Fao Adam Walker
Kirklees Metropolitan Council
Planning Services
P.O. Box B93
Civic Centre III
Market Street
Huddersfield
HD1 2JR

21 March 2021

Proposed erection of foodstore (Use Class E) with associated, servicing areas and landscaping at former Spotted Cow Pub, New Hey Road, Oakes, Huddersfield HD3 4BU (application reference 2020/93308).

1 - EAST /SIDE RETAINING WALL

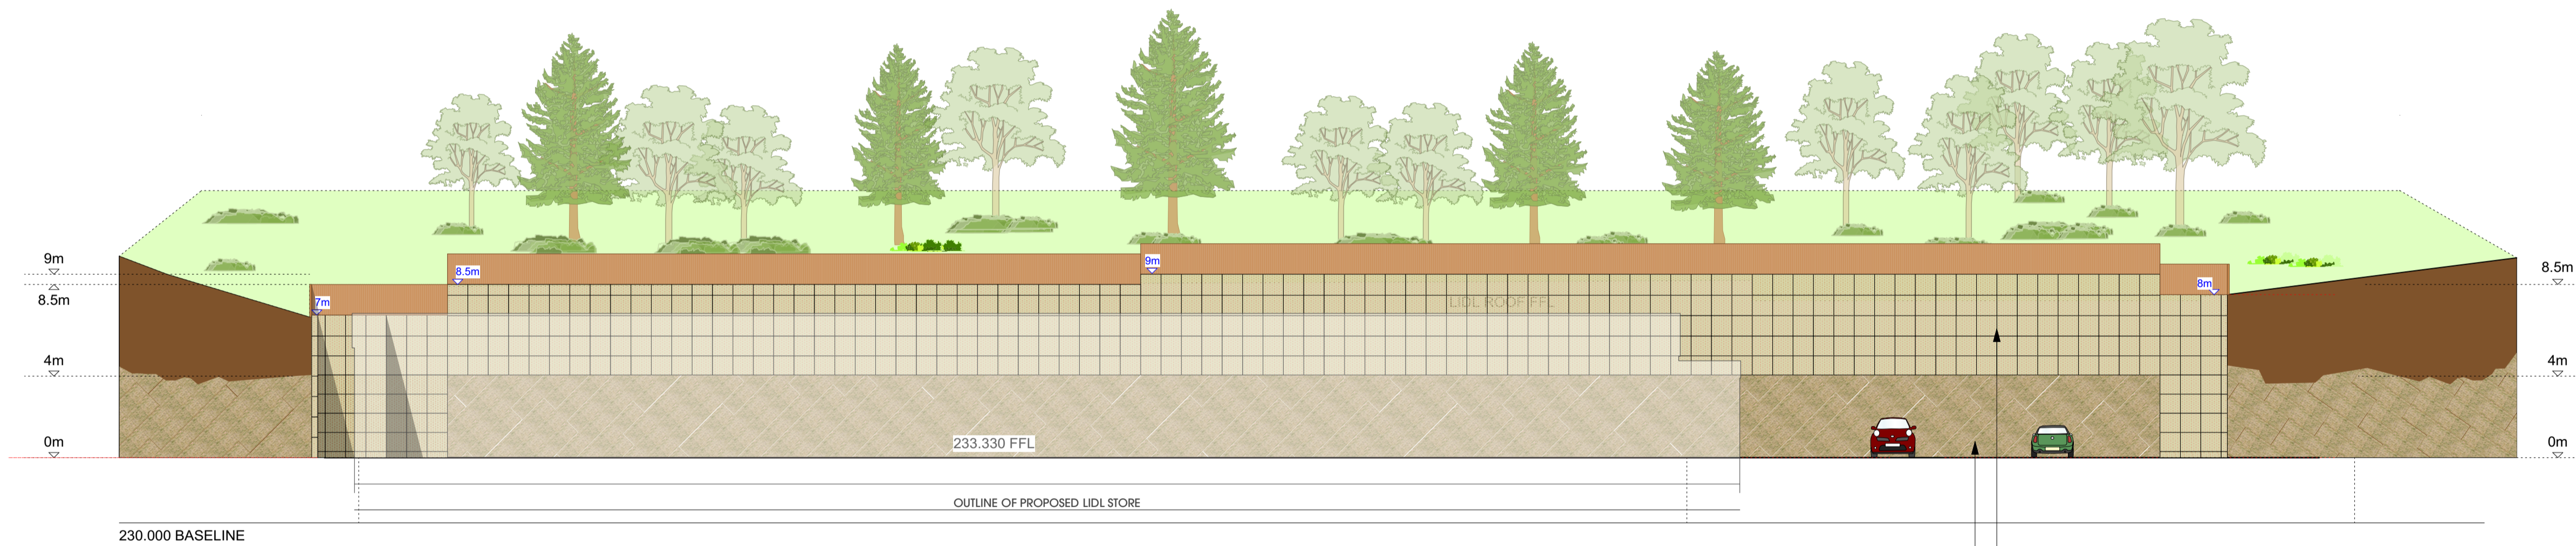
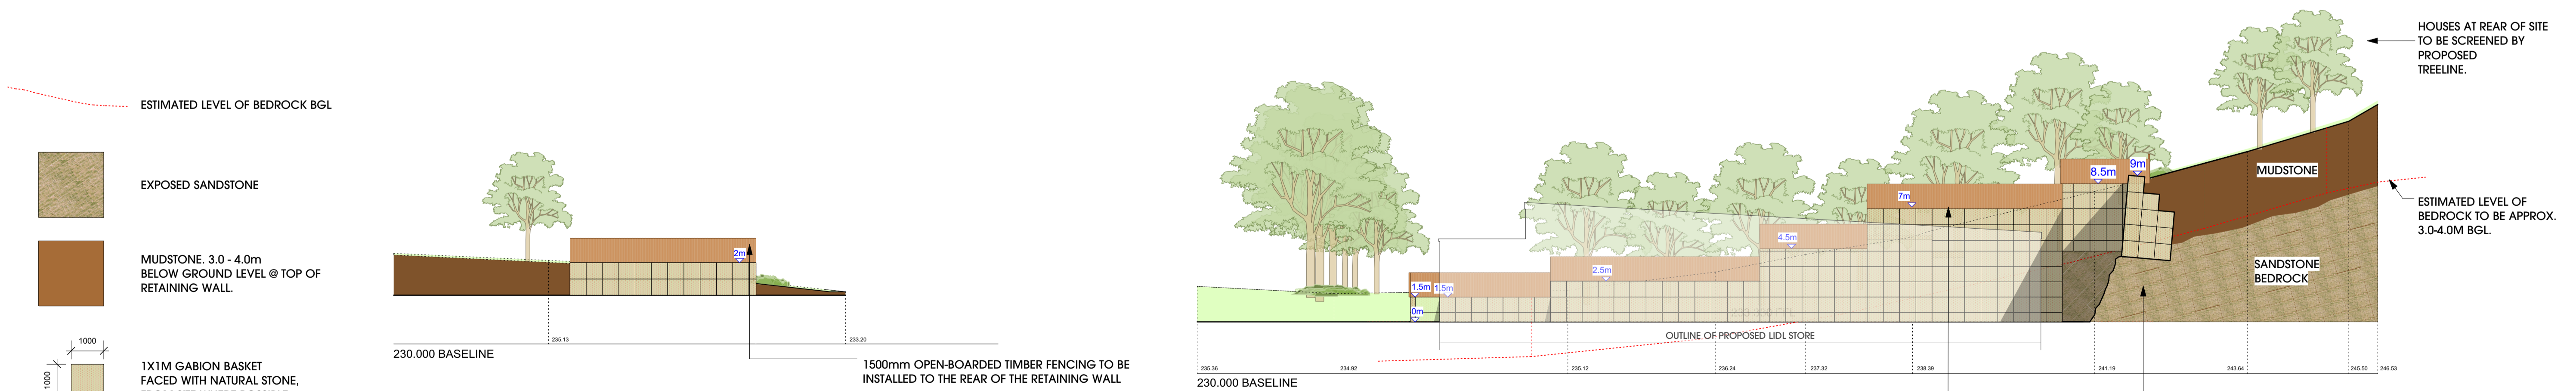
Furthermore, on a more detailed level, the amount of digging out towards the back of the site to accommodate the store itself, car parking and servicing vehicles results in a high, unsightly backcloth to the car-parking at the site's north-eastern corner.

To remove from the site the amount of material proposed would be contrary to good practice as part of the Council's green agenda of retaining as much material on site.
